Re: Planning application **6/2023/0005/HOUSE**

MRS GLORIA ROWLAND
Home Extension
391 St Albans Road West, Hatfield, AL10 9RU
Proposed Gound, First & Roof Plan

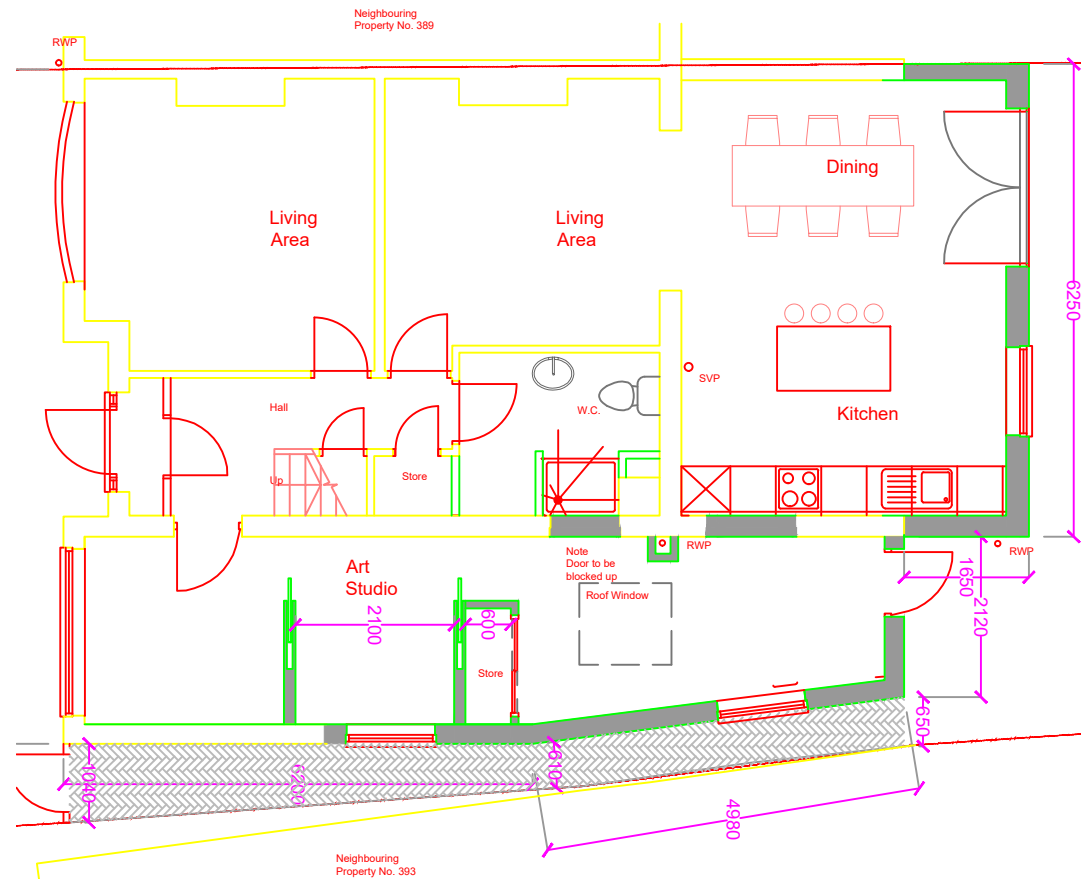
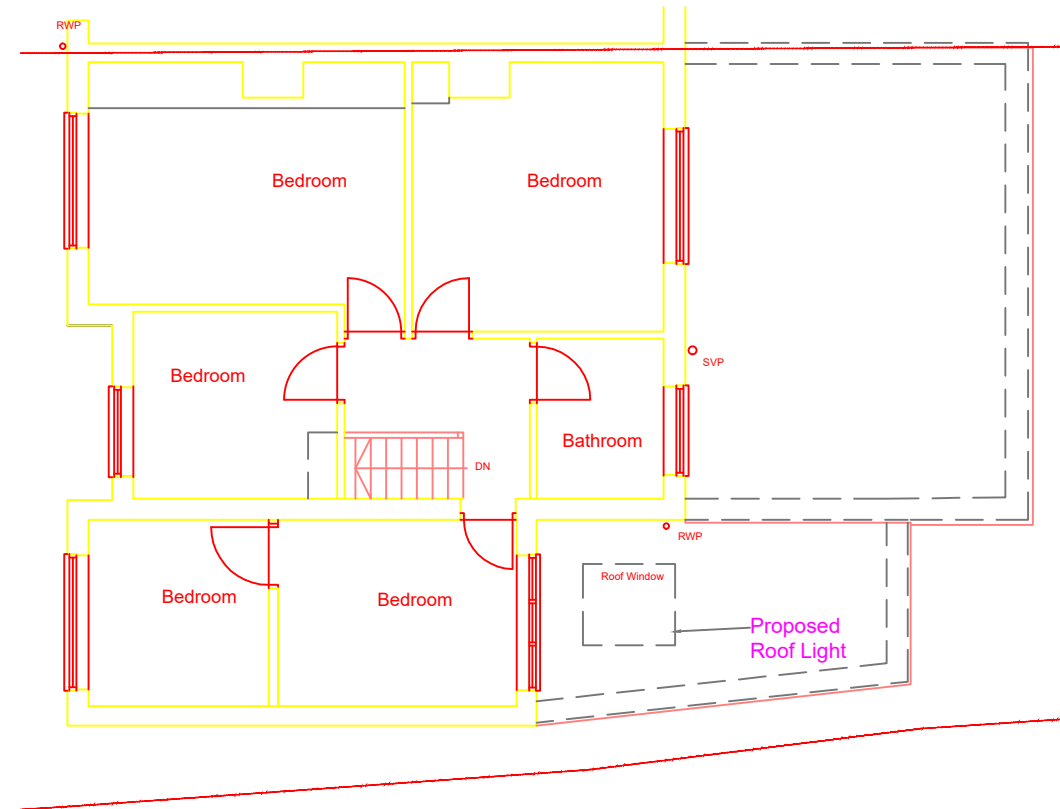
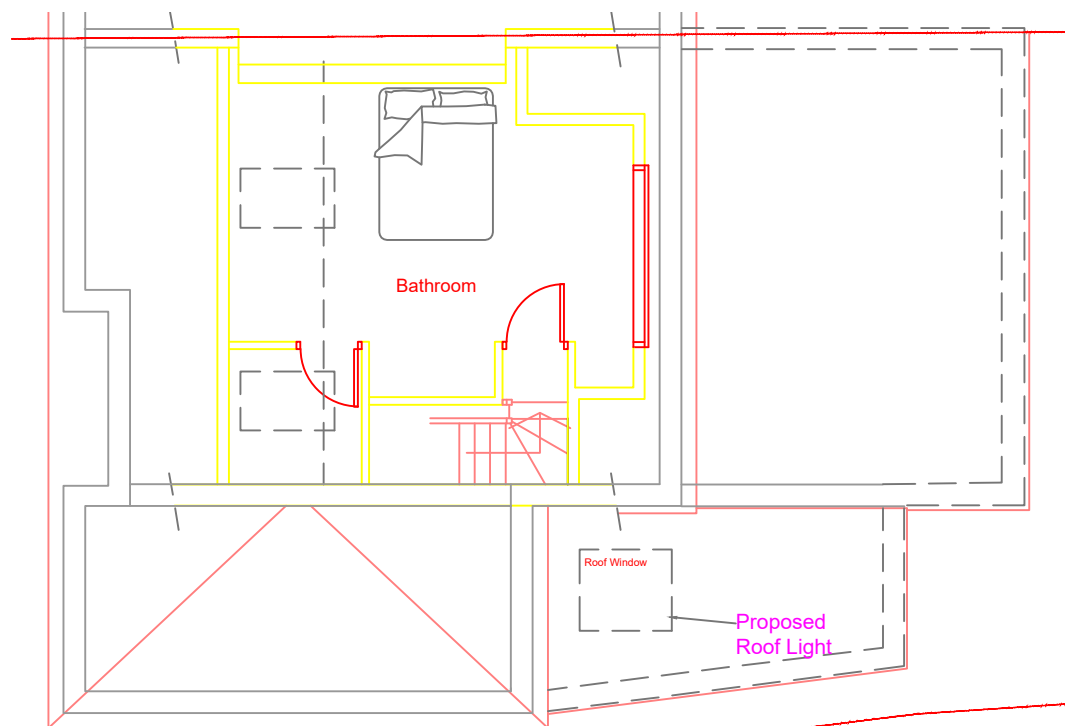
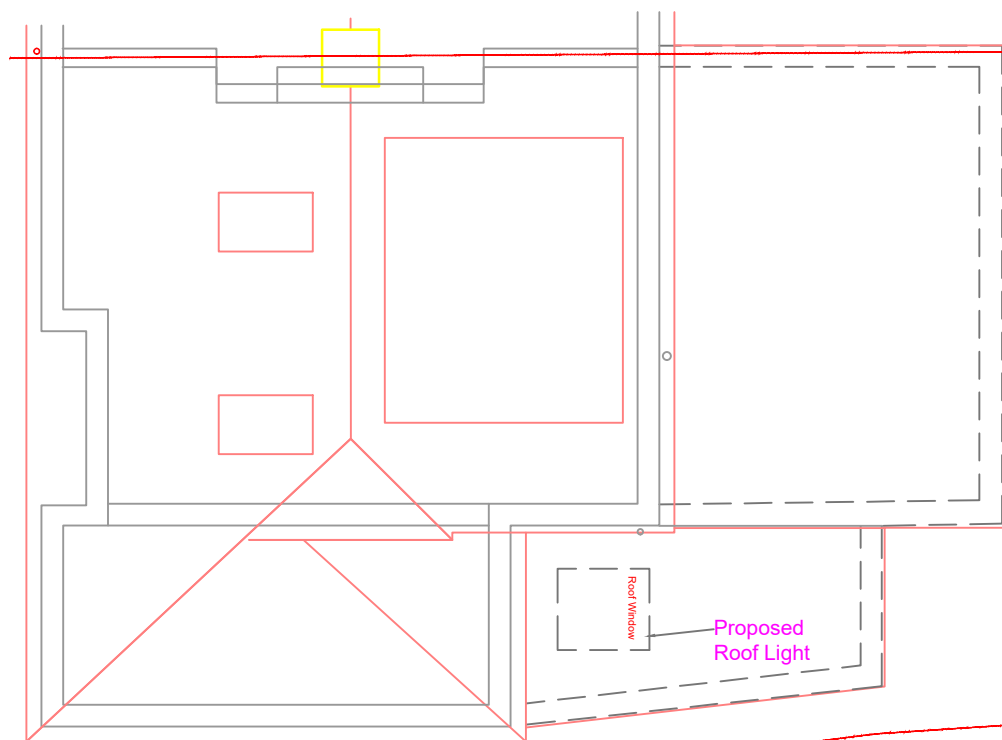
The proposed plans look to double the number of bedrooms to 6, which highlights another error in the 'Proposed Floor Plans' as the second floor room is labelled as a bathroom with a bed in it. We have already raised the following concerns on a previous application (6/2022/2029/FULL) and they still stand:

MRS GLORIA ROWLAND
Home Extension
391 St Albans Road West, Hatfield, AL10 9RU
Existing Elevations

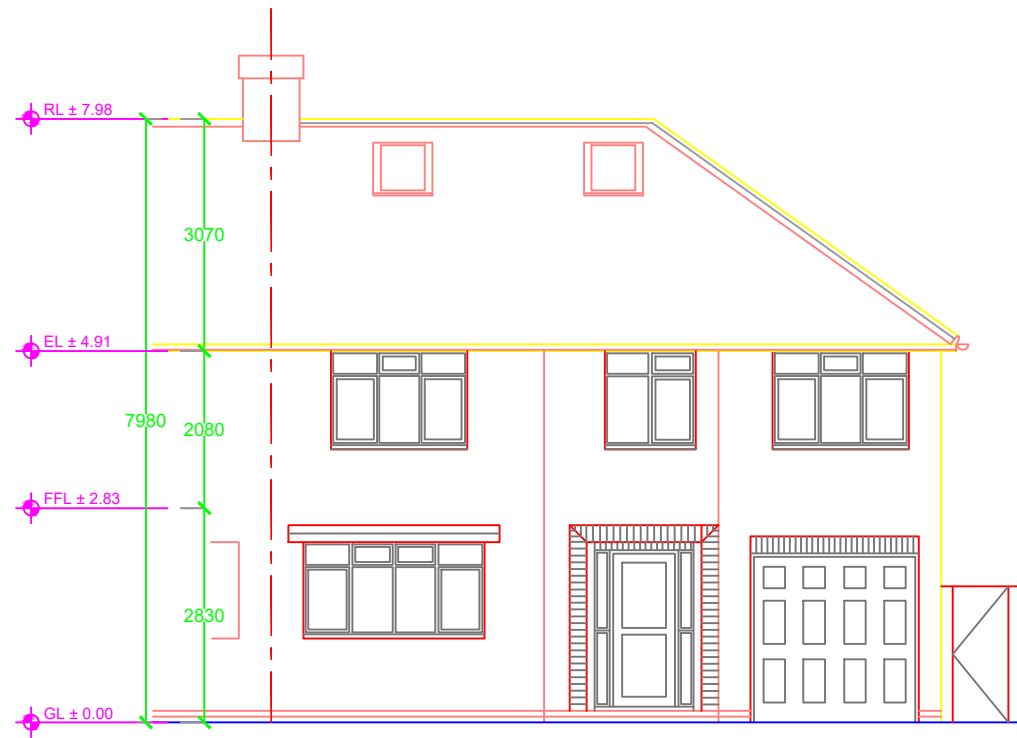
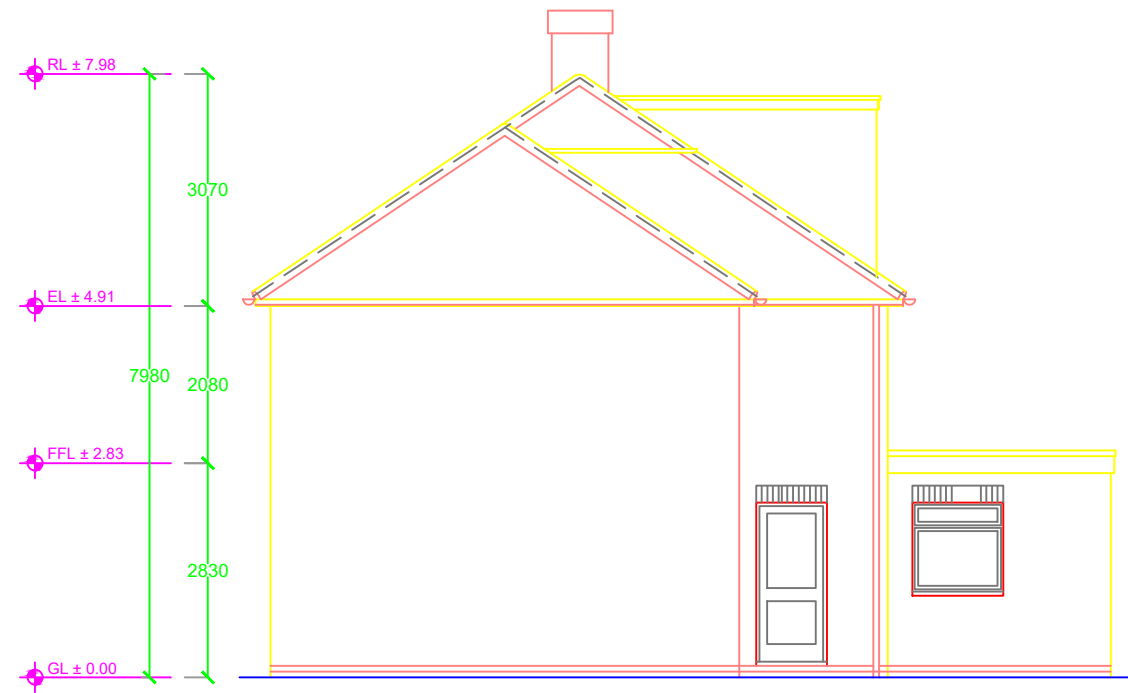
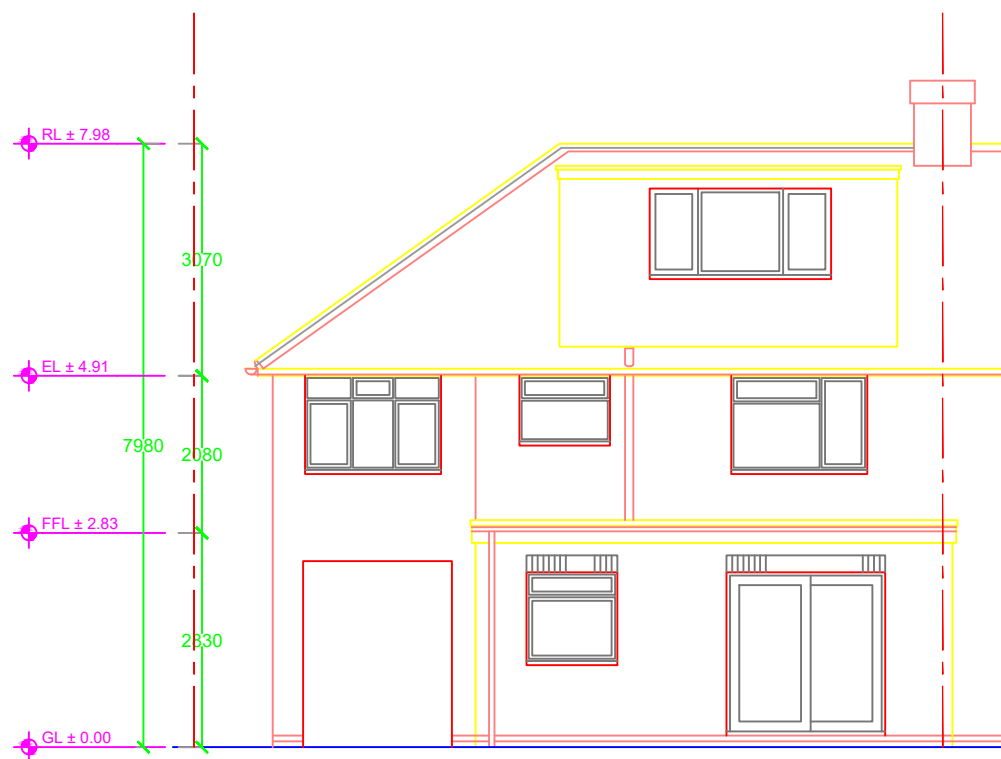
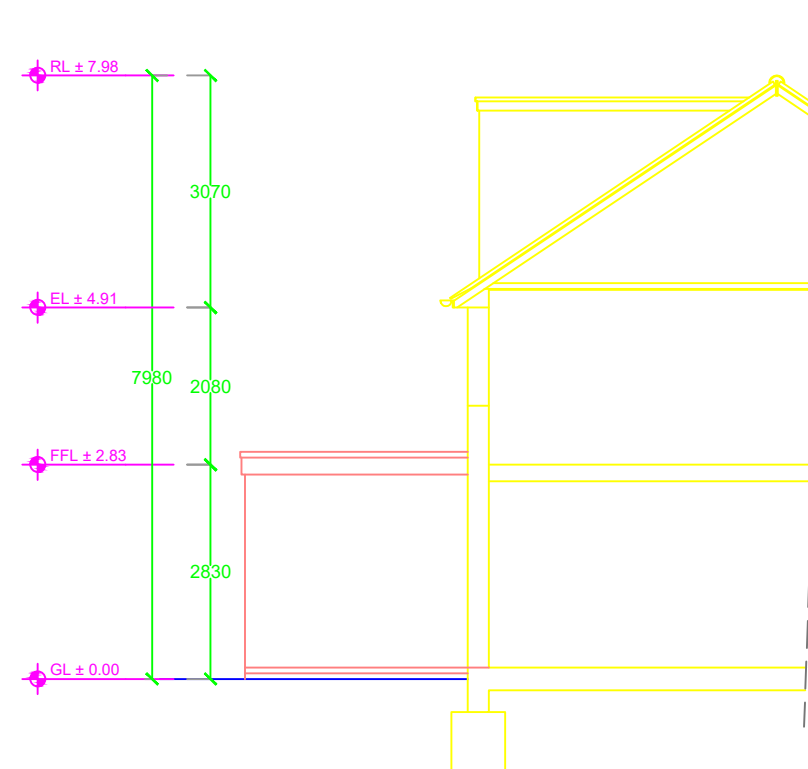
The existing elevations and site plan are inaccurate. There are currently no roof windows on the front elevation and no dormer style structure on the rear. The rear of the property currently has a double storey extension with a pitched roof, joined to the main roof, which is omitted from the 'Existing Elevations' document.

MRS GLORIA ROWLAND  
Home Extension  
391 St Albans Road West, Hatfield, AL10 9RU  
Existing Shed 01  
Ground Floor & Roof Plan  
Elevations

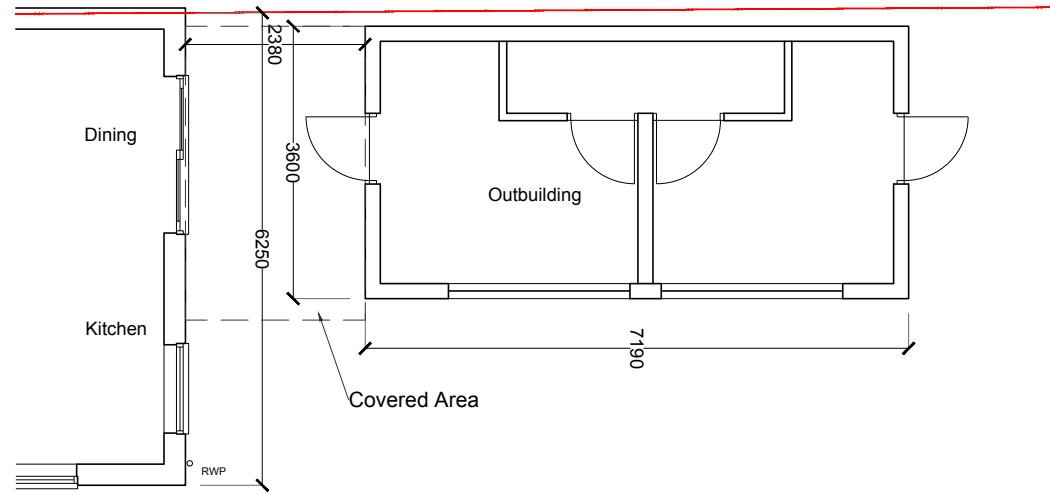
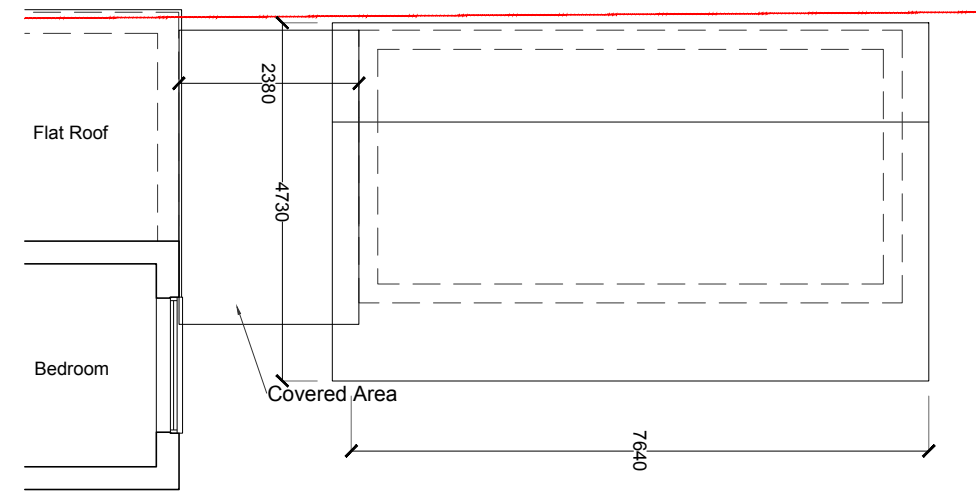
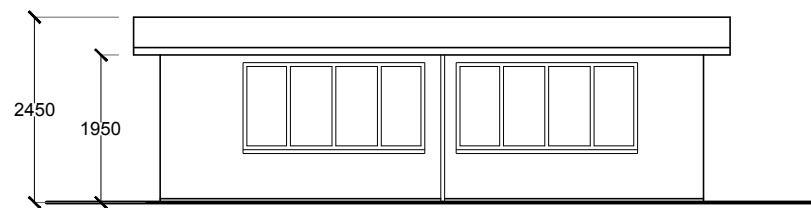
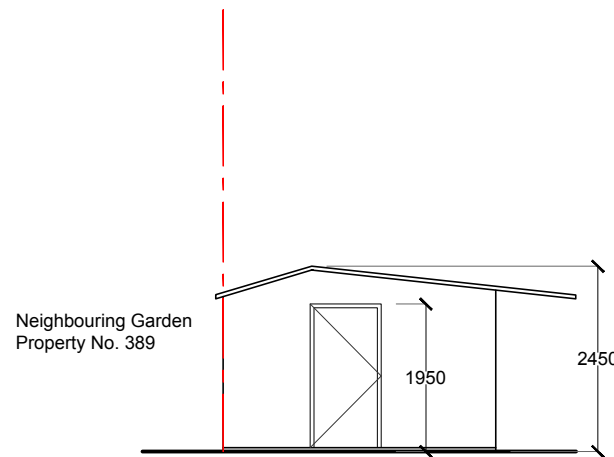
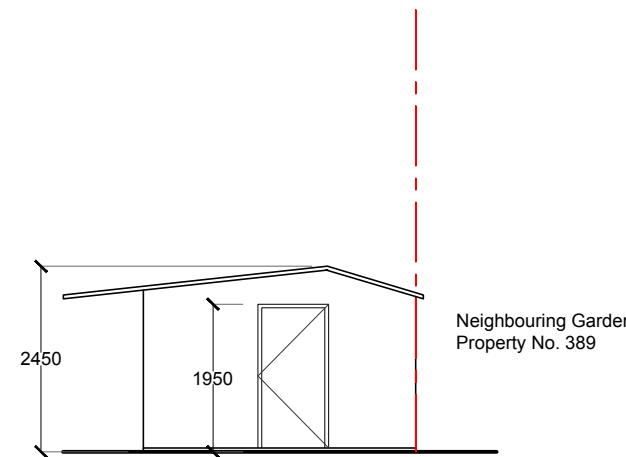
There is already a large outbuilding which has been omitted from the proposed plans. Permission was granted previously (S6/2014/2413/LUP) for a 'games room' and the plans stated 4800mmx4200mm. I do not have exact measurements but it is at least 8000mm in length.
